**WEST SUSSEX COUNTY COUNCIL
STRATEGIC PLANNING CONSULTATION**

SUBJECT: Y/93/14/OUT

Outline application with some matters reserved for the erection of 40no dwellings each with a garage and or parking spaces, together with the means of access off North End Road.

Land North Of, Yapton C of E Primary School, North End Road, Yapton, West Sussex, BN18 0DU

DRAWING NO YAP/DR/1

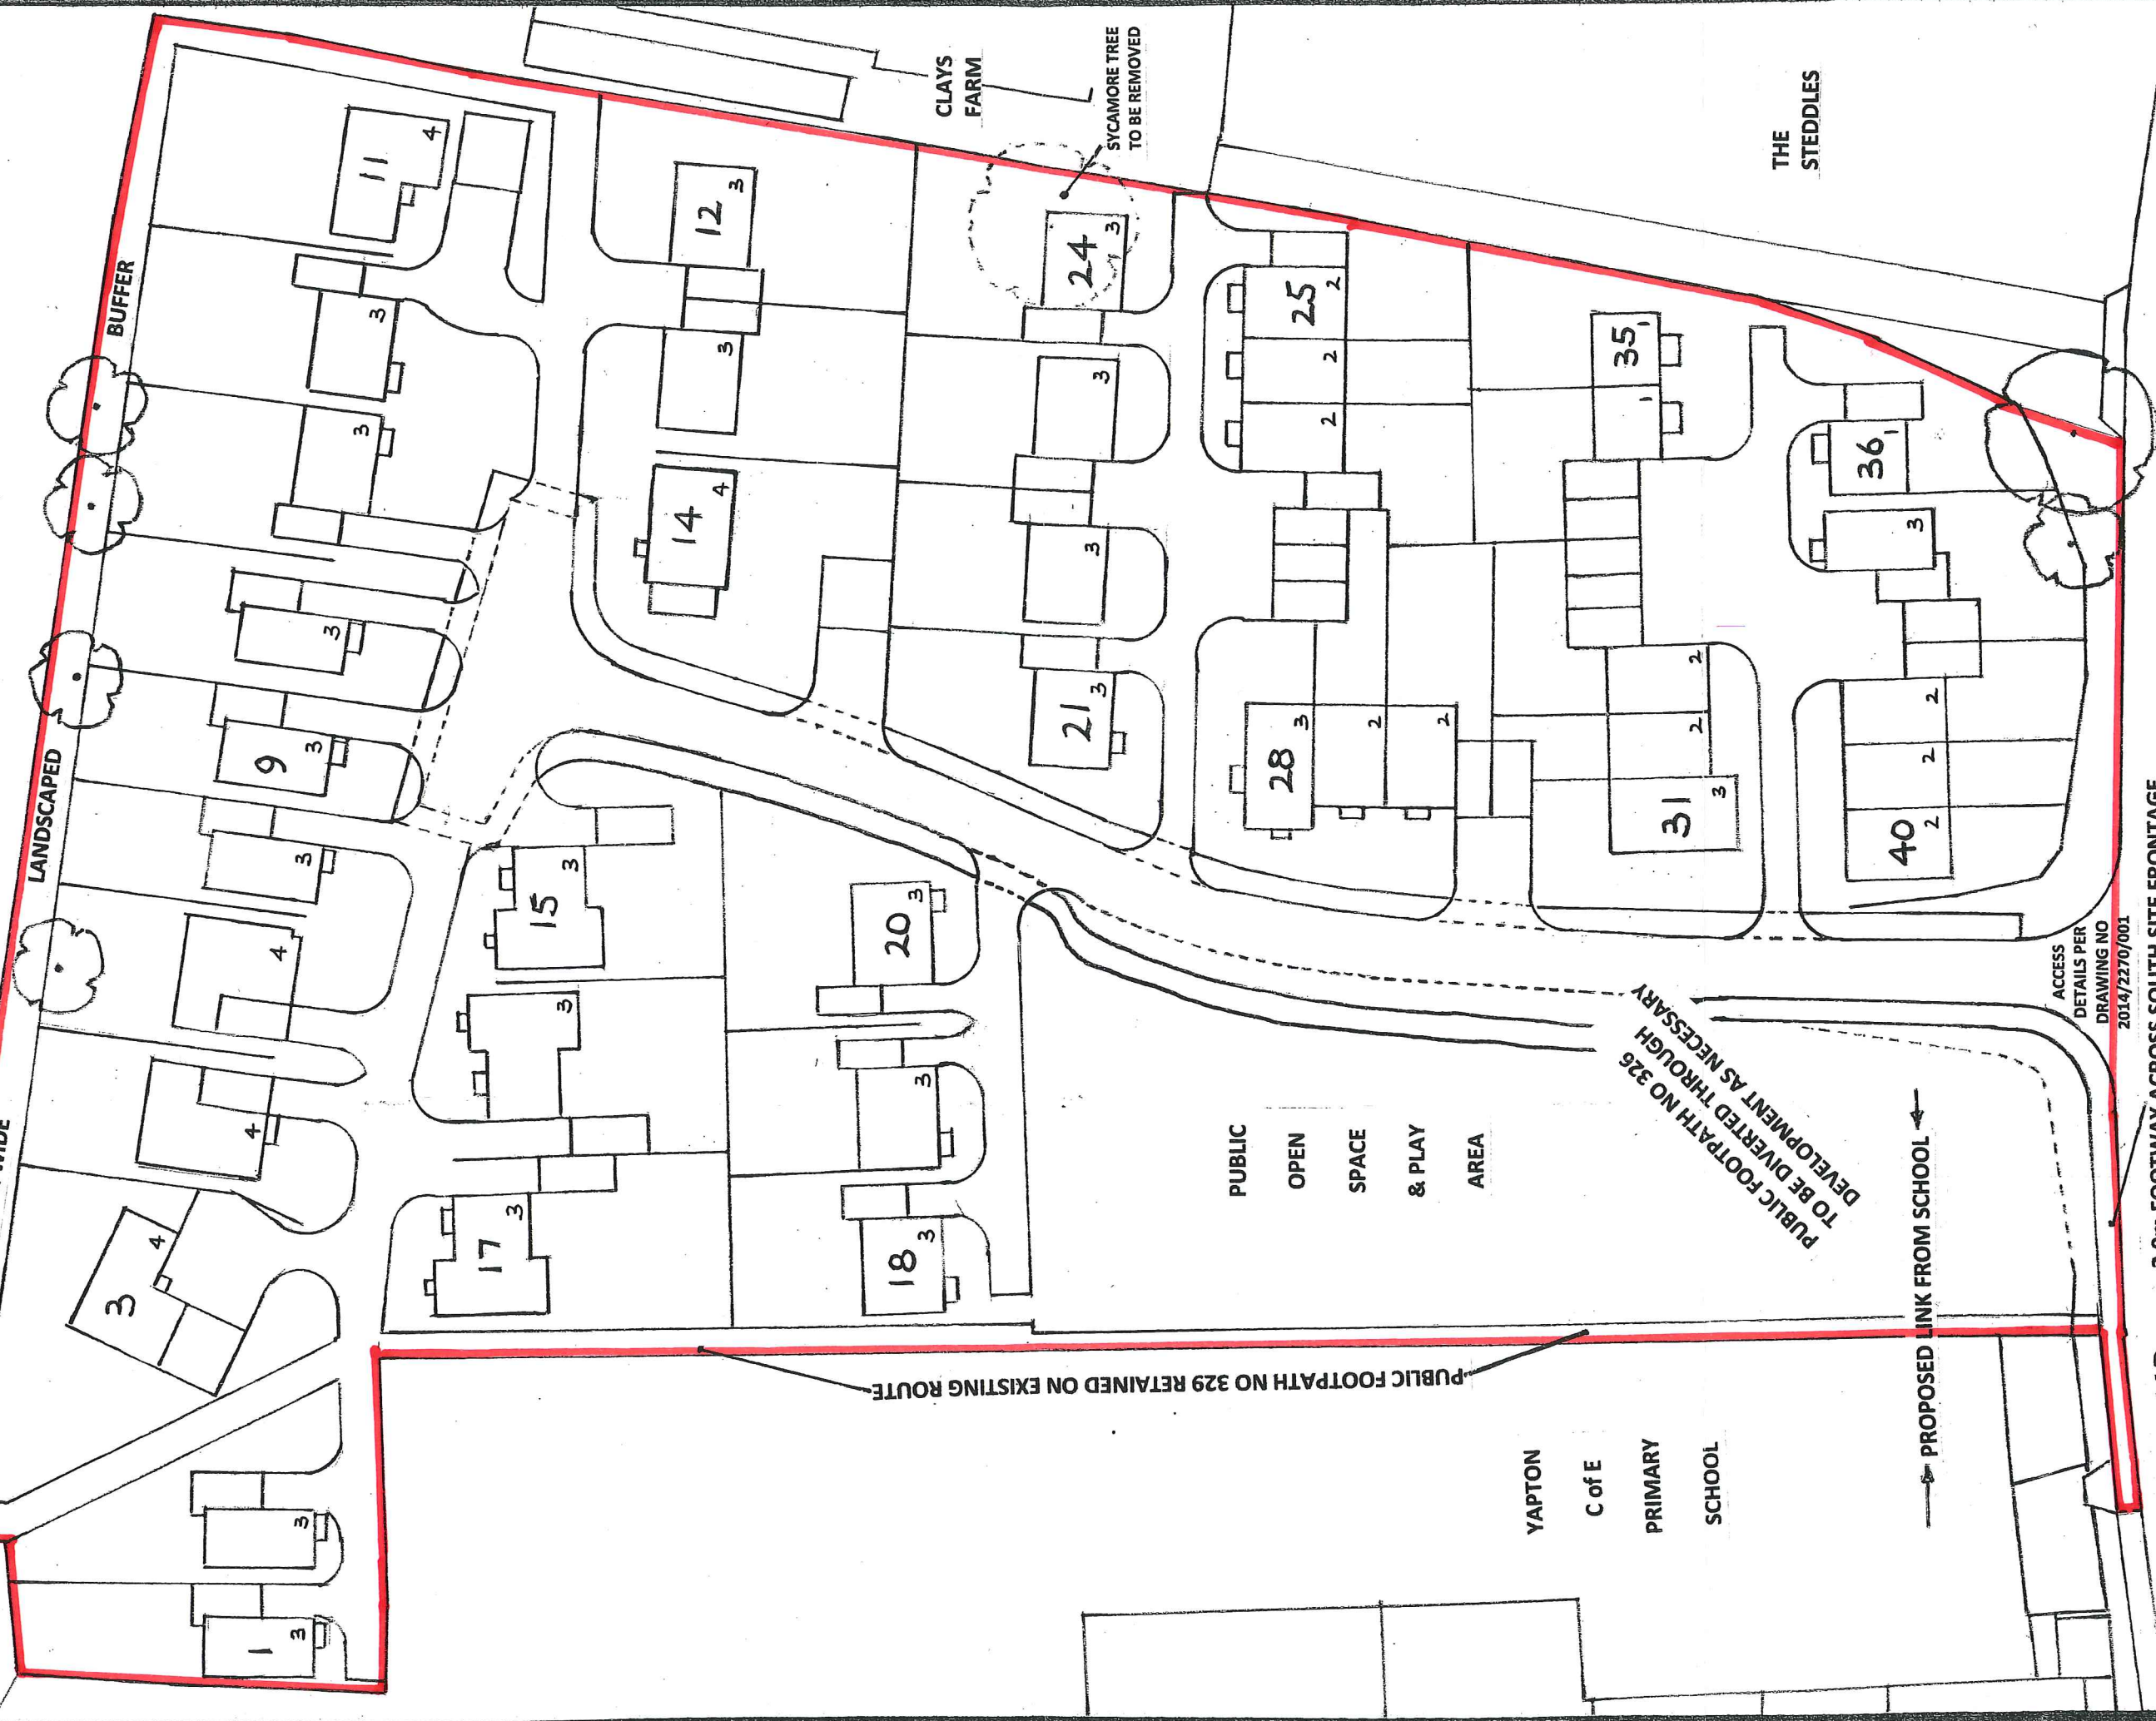
The proposed site access takes the form of a priority junction with the site access road forming the minor arm. Visibility splays have been based on the recorded 85th percentile speed along North End Road in accordance with the methodology set out in the Design Manual for Roads and Bridges (DMRB) and Manual for Streets (MfS). In accordance with 1.3.6 and 1.3.7 of MfS2 it is considered appropriate for MfS visibility parameters to be used. Splays of 2.4m x 76m to the north and 2.4m x 67m to the south are considered to be appropriate and should be secured by condition.

A Road Safety Audit: Stage 1 has been undertaken on the proposed site access arrangements. A problem relating to an uneven vehicle cross-over has been accepted and the cross-over will be reinstated as part of the footway works. A problem relating to obstruction of visibility and consideration of alternative junction control, such as a mini-roundabout, was not accepted by the Designer. The reasons behind this position have been reviewed by the WSCC Lead Safety Auditor and WSCC Improvements Manager through an 'Exception Report' in accordance with Highway

The primary attractors for non-vehicular trips are located to the south of the site and include Yapton village, school, public house etc. The Applicant proposes to tie into the existing network by way of a 2m footway across the site frontage that connects into the site.

As referenced earlier in this report, the RSA has raised a concern in regard to parking in the visibility splay. As part of the Exception Report it was identified that some land would be made available for use by the school as additional staff parking. This land should be marked up on a plan and secured via a Section 106 Agreement.

No part of the development shall be first occupied until visibility splays of 2.4 metres by 76m to the north and 2.4m by 67 metres to the south have been provided at the proposed site vehicular access onto North End Road in accordance with the approved planning drawings. Once provided the splays shall thereafter be maintained and kept free of all obstructions over a height of 0.6 metre above adjoining carriageway level or as otherwise agreed.

An area of land to be dedicated for use by Yapton CE as a parking facility
